Reference No:	2026/62/91163/E
Site Address:	The West, 22, High Street, Westtown, Dewsbury, WF13 2PU
Description:	Erection of first floor extension and canopy with associated alterations
Recommending Officer:	Jennifer Booth

DECISION - REFUSED

OFFICER REPORT

PROPOSED SITE PLAN

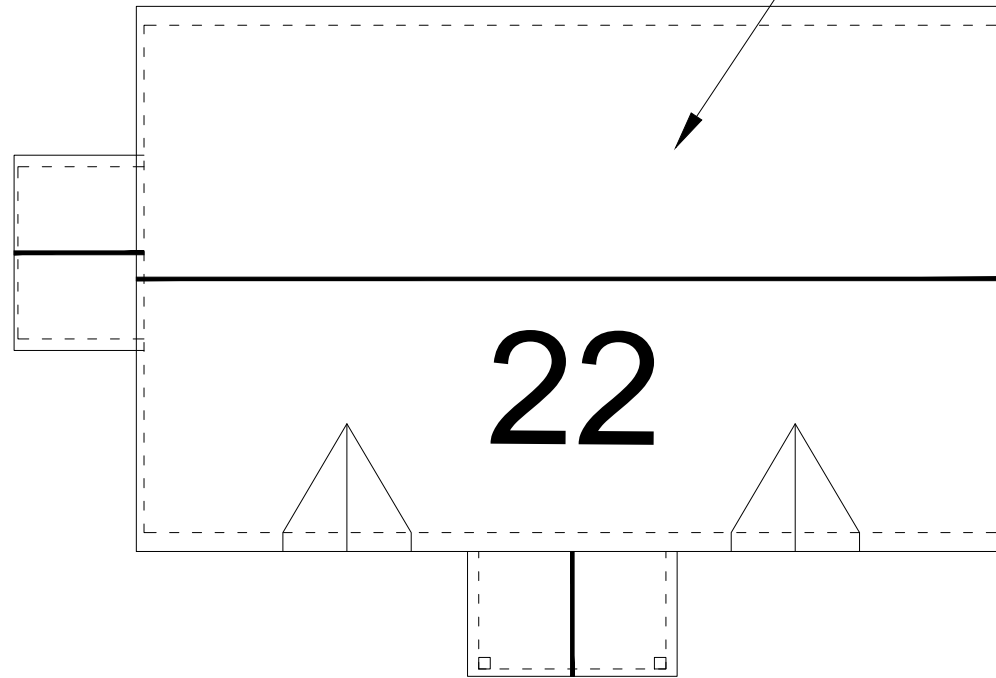
The adjacent dwelling to the west occupies a position some 18m from the site with Boothroyd Green between, which would minimise the potential for the proposed extension to result in any significant overbearing or overshadowing. There are no windows proposed in the side elevation and as such, there would be no overlooking.

PROPOSED FIRST FLOOR PLAN

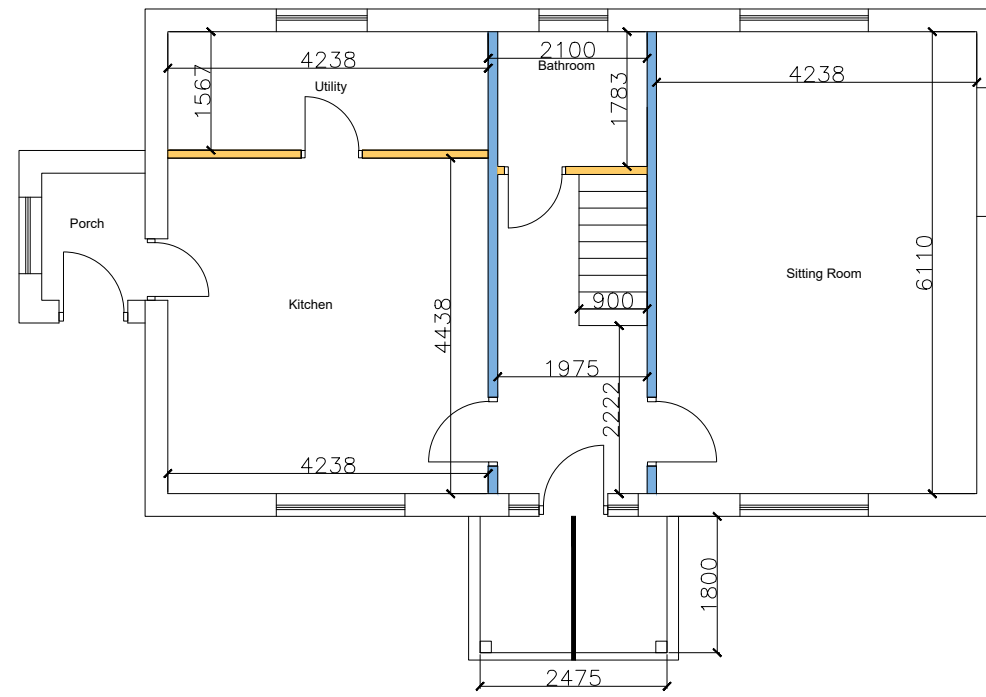
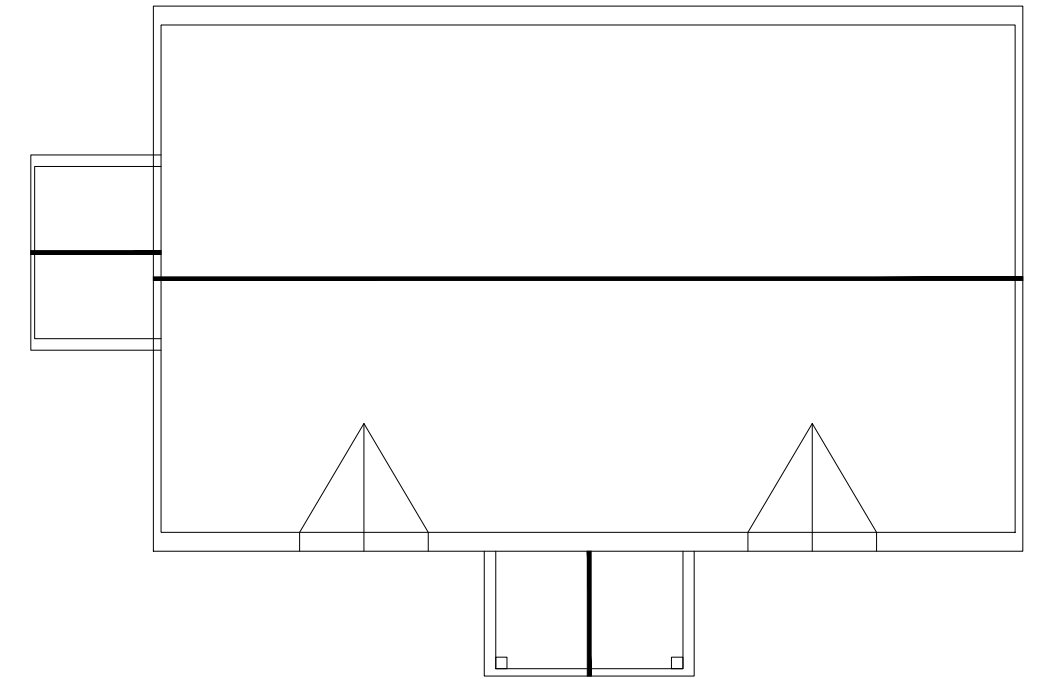
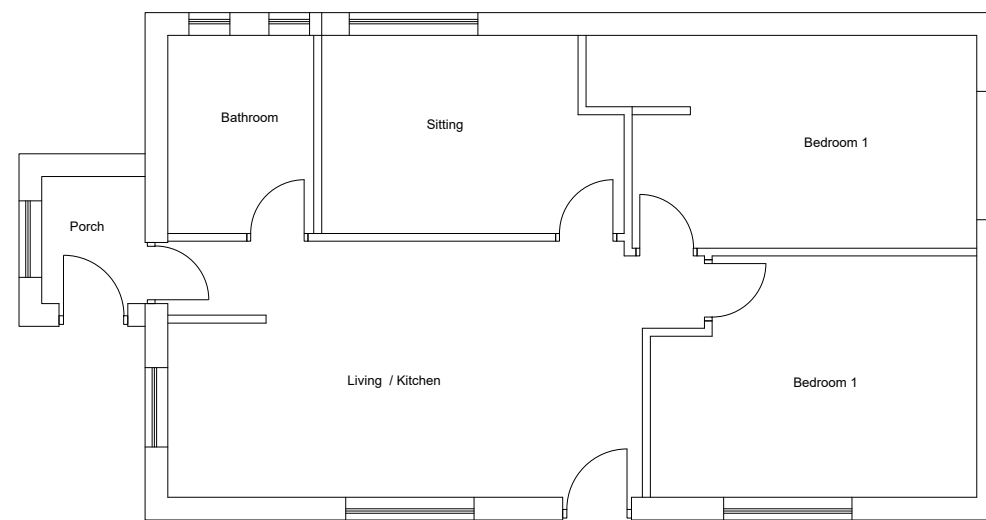
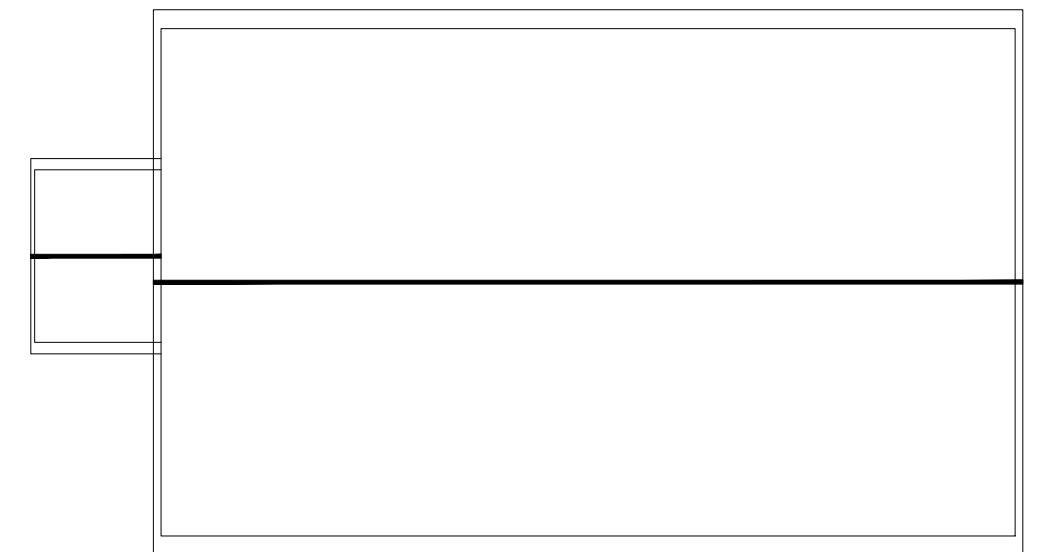
The proposed development seeks to extend the existing bungalow upwards to form a full first floor, resulting in a substantial increase in the overall height, scale, and bulk of the dwelling. This form of development would fail to appear subservient to the host property and would instead fundamentally alter its established character and appearance as a bungalow. The introduction of a full two-storey structure would erode the defining proportions of the original dwelling, resulting in a building that appears overly dominant and at odds with its original form.

that overwhelms the existing bungalow, leading to a loss of its simple, low-profile character. Consequently, the development would appear visually intrusive when viewed within the street scene, particularly given the site's prominent position.

Although the use of matching materials and similar detailing is noted and would assist in achieving some degree of visual cohesion, this approach does not outweigh the fundamental concerns regarding the scale, massing, and transformation of the building's character. The proposal is therefore considered to result in an incongruous form of development that is harmful to visual amenity.

The proposed extension, by reason of its excessive scale, height and massing, would fail to appear as a subservient addition and would fundamentally alter the character and proportions of the original bungalow. The development would result in a dominant and visually intrusive form that is incongruous to the host dwelling and harmful to the visual amenity of the street scene, particularly given the site's prominent position. The proposal is therefore contrary to Policy LP24 (criteria a and c) of the Kirklees Local Plan, KDP1 and KDP2 of the House Extensions and Alterations Supplementary Planning Document, and the design objectives set out in Chapter 12 of the National Planning Policy Framework.

1. The proposed extension, by reason of its excessive scale, height and massing, would fail to appear as a subservient addition and is of poor design that would fundamentally alter the character and proportions of the original bungalow to the detriment of the host and character of the locality. The development would result in a dominant and visually intrusive form that is incongruous to the host dwelling and harmful to the visual amenity of the street scene, particularly given the site's prominent position. The proposal is therefore contrary to Policy LP24 (criteria a and c) of the Kirklees Local Plan, KDP1 and KDP2 of the House Extensions and Alterations Supplementary Planning Document, and the design objectives set out in Chapter 12 of the National Planning Policy Framework.
